Subject: The Estates at Rolling Hills Ranch PUD Development Plan, Preliminary Plan and Filing No. 1 Final Plat (PUDSP-19-007, SF-19-019)

The Planning Division of the Community Services Department has reviewed The Estates at Rolling Hills Ranch PUD Development Plan, Preliminary Plan, and Filing No. 1 Final Plat applications, and has the following preliminary comments of behalf of El Paso County Parks. This application and the following comments and recommendations will be presented to the Park Advisory Board on November 13, 2019:

DRAWN BY: LCG	DATE: JULY 2019
CHECKED BY: TAK	SHEET: 2 OF 5

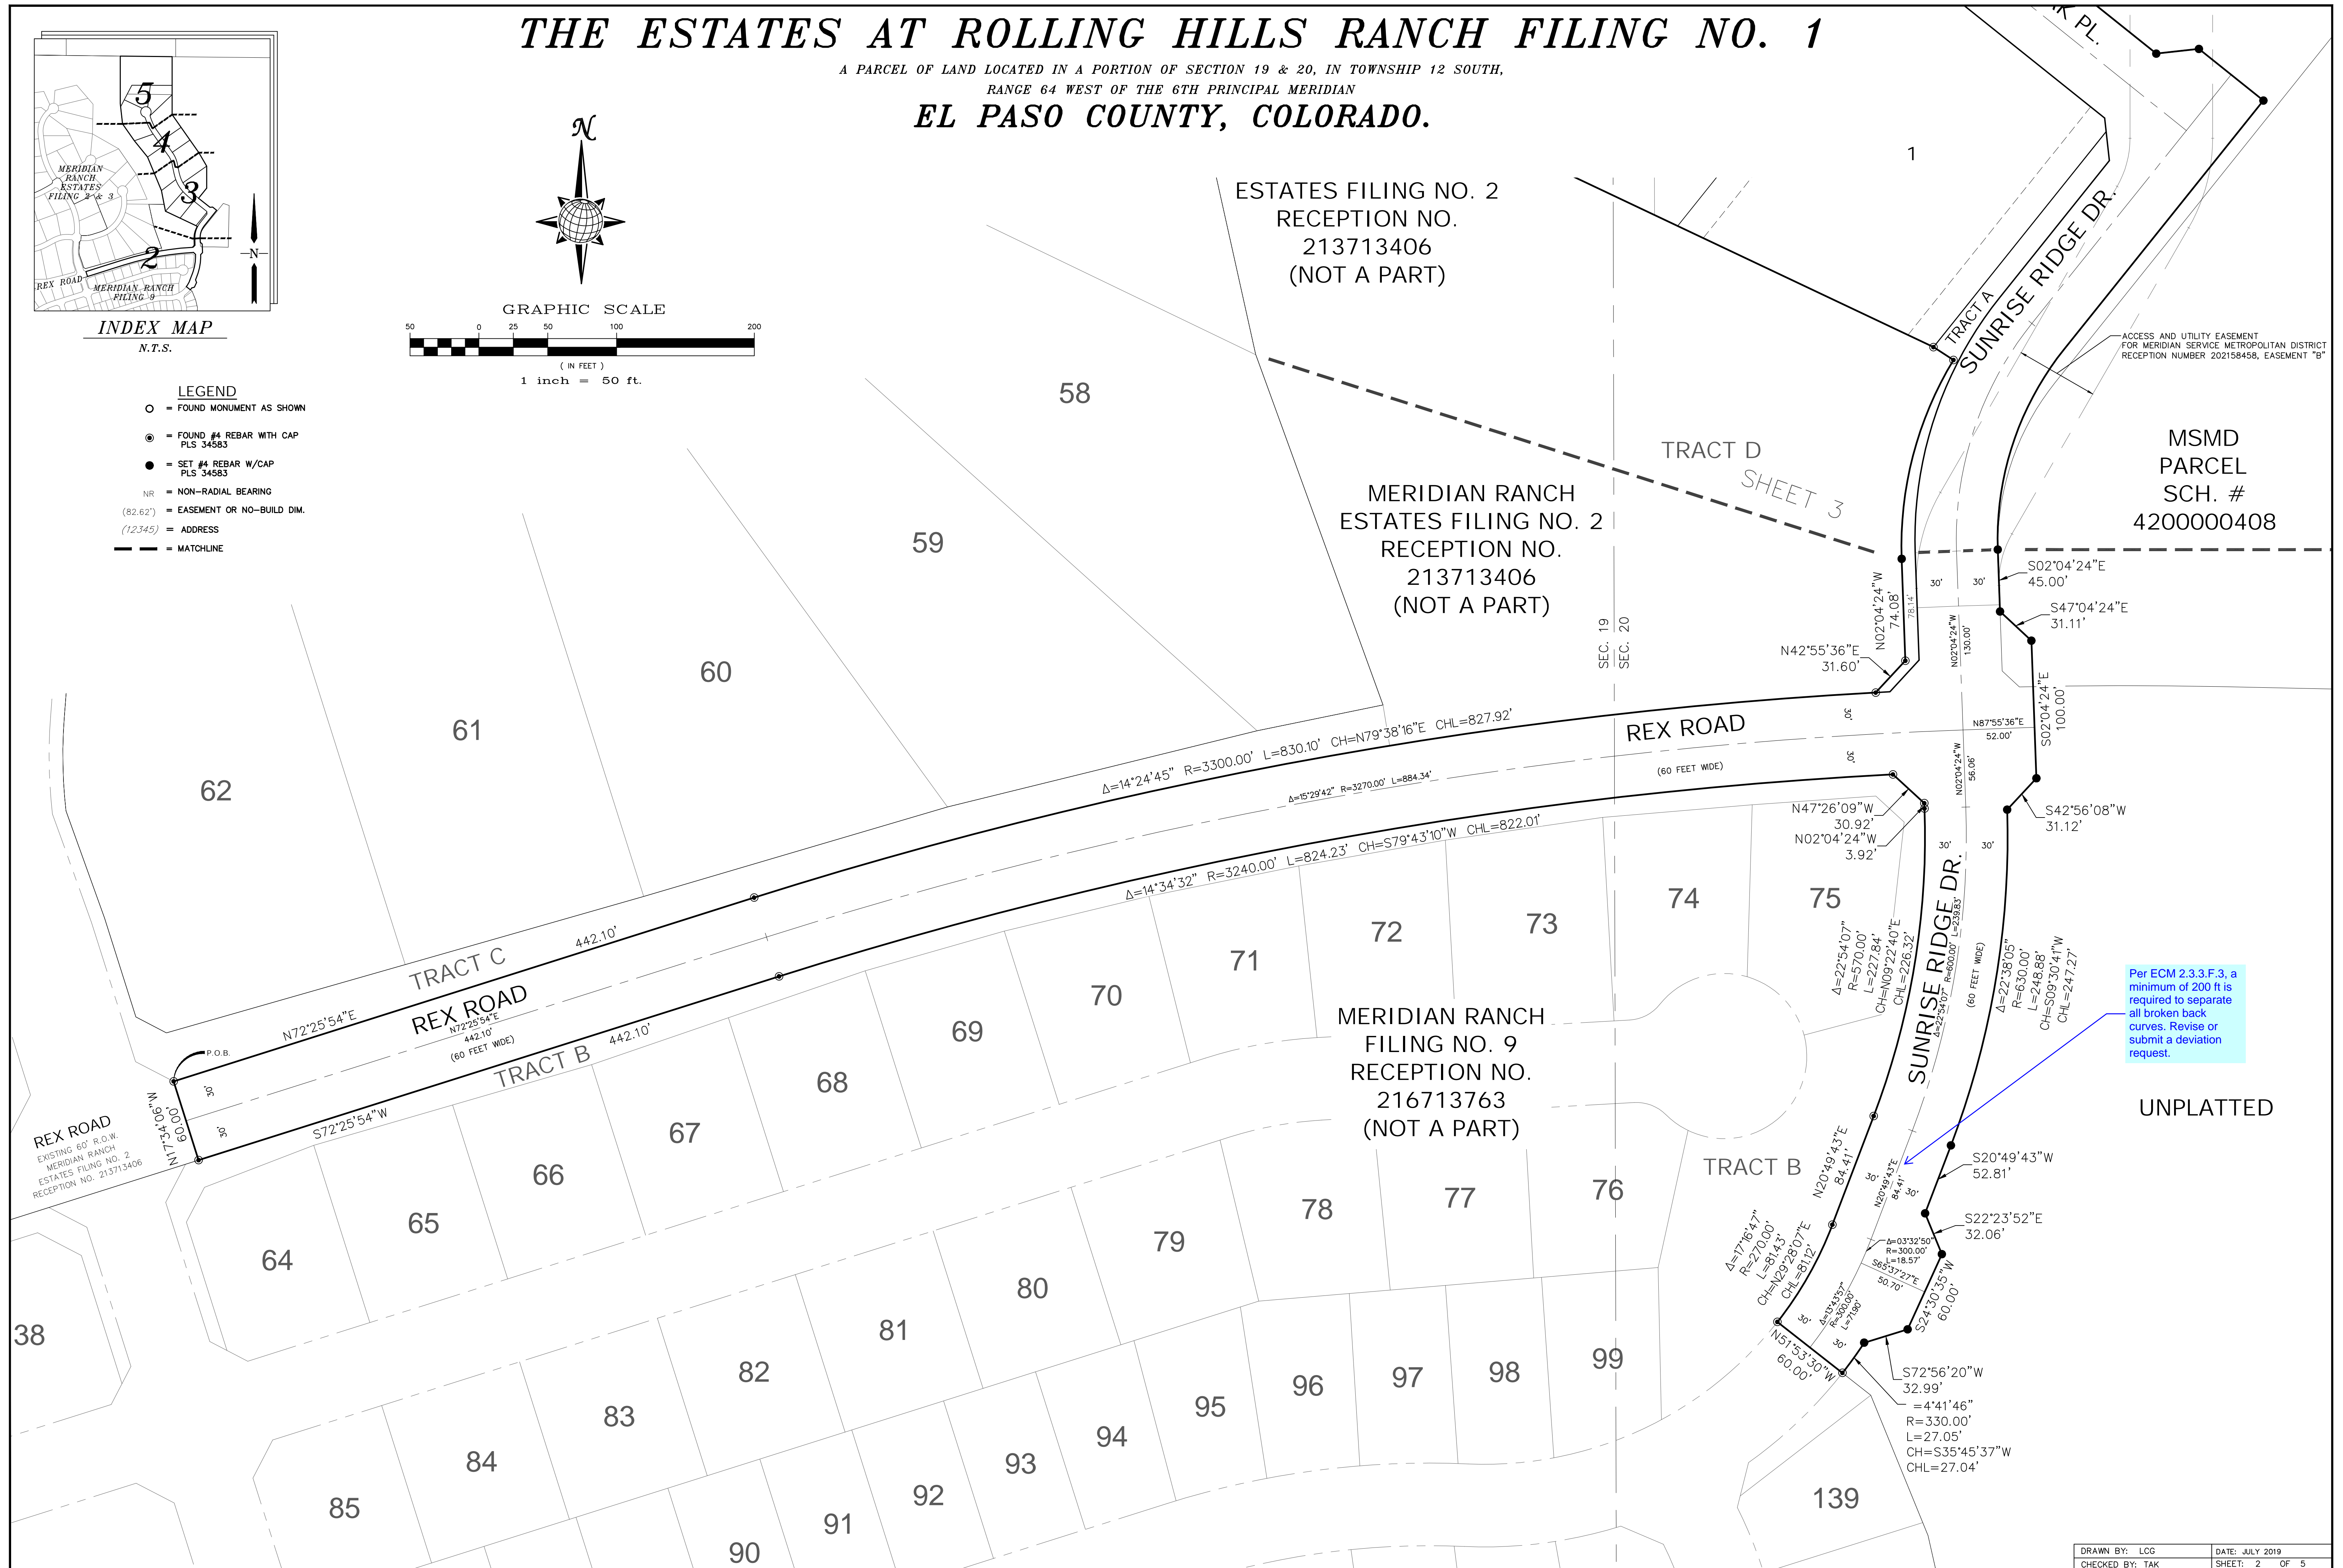
The current PUD Development Plan and Preliminary Plan show a 25-foot trail easement along the northern boundary of the project site, however, the Final Plat notes do not reference the dedication of the trail easement to El Paso County. As such, staff recommends that the applicant designate and provide to El Paso County a 25-foot trail easement along the northern boundary of The Estates at Rolling Hills Ranch Filing No. 1 Final Plat, within Tract A, that allows for public access of the Meridian Ranch Secondary Regional Trail, and dedicate the aforementioned easement to El Paso County prior to the recording of the Final Plat.

Recommend to the Planning Commission and the Board of County Commissioners that approval of The Estates at Rolling Hills Ranch Filing No. 1 Final Plat include the following conditions: (1) designate and provide to El Paso County a 25-foot trail easement along the northern boundary of The Estates at Rolling Hills Ranch Filing No. 1 Final Plat, within Tract A, that allows for public access of the Meridian Ranch Secondary Regional Trail, and dedicate the easement to El Paso

County prior to the recording of the Final Plat; (2) regional park fees are not required pursuant to the existing Park Lands Agreement for regional park land dedication; and (3) require fees in lieu of land dedication for urban park purposes in the amount of \$4,608. A Park Lands Agreement may be an acceptable alternative to urban park fees, provided the agreement is approved by the County and executed prior to recording this Final Plat.
